INDEPENDENT EXPERT ADVISORY PANEL FOR MINING

***Metropolitan Coal Mine:
Independent review of environmental
performance to 2022***

September 2023

Report No: IEAPM 202309-2

Figure 9 Groundwater hydrographs for bore T5 compared with reservoir water level, rainfall, bore T3 and neighbouring VWP sensors at a similar elevation

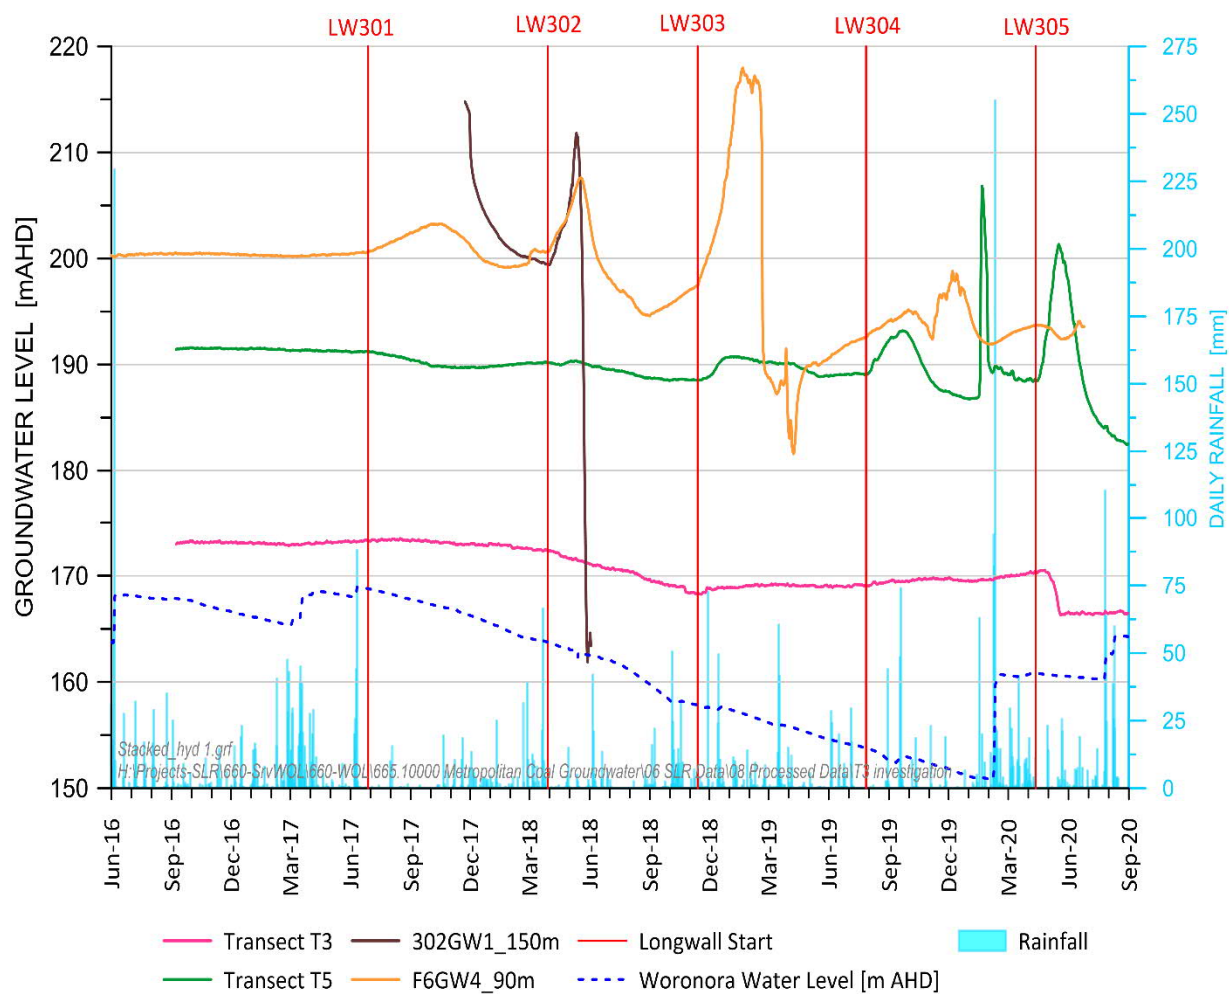
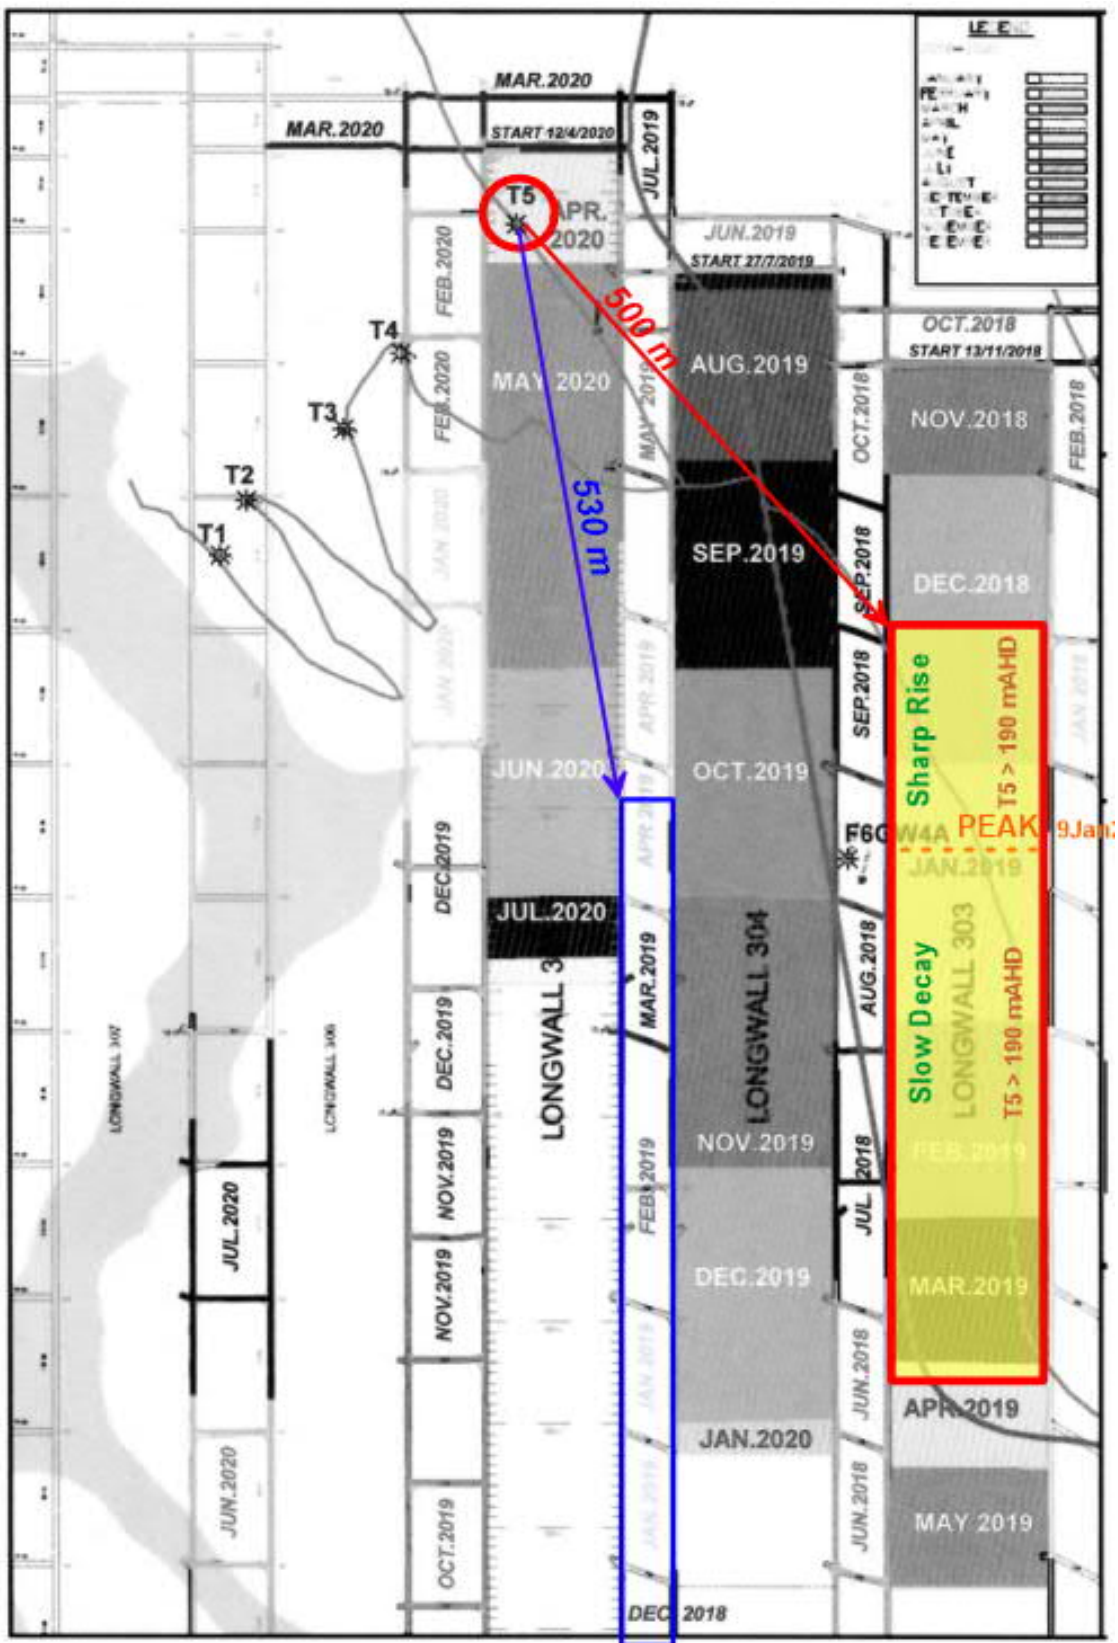
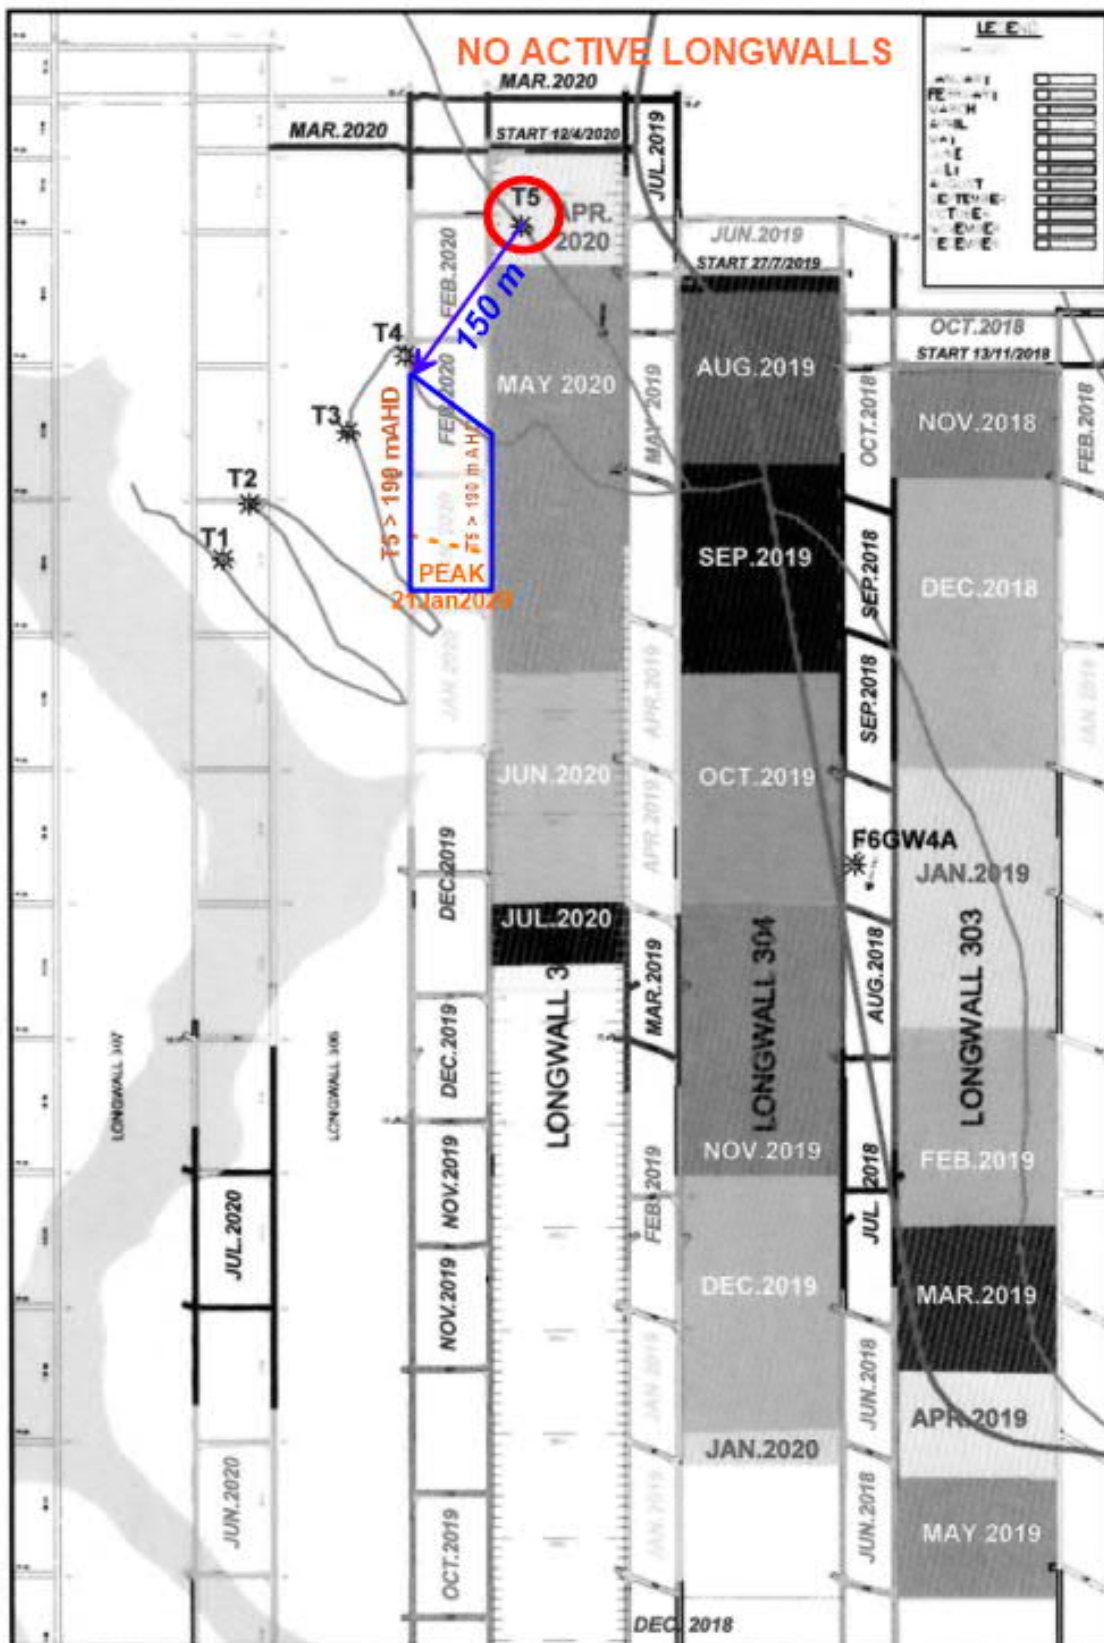
1. Additional bores (standpipes) be established at the T5 monitoring location to monitor the vertical piezometry in the Hawkesbury Sandstone and to establish whether extensive basal shears occur at depth below this eastern ridgeline area.
2. Additional bores (standpipes) be established at the T6 monitoring location and at other accessible locations overlying the proposed LW311 to LW316 panels as soon as
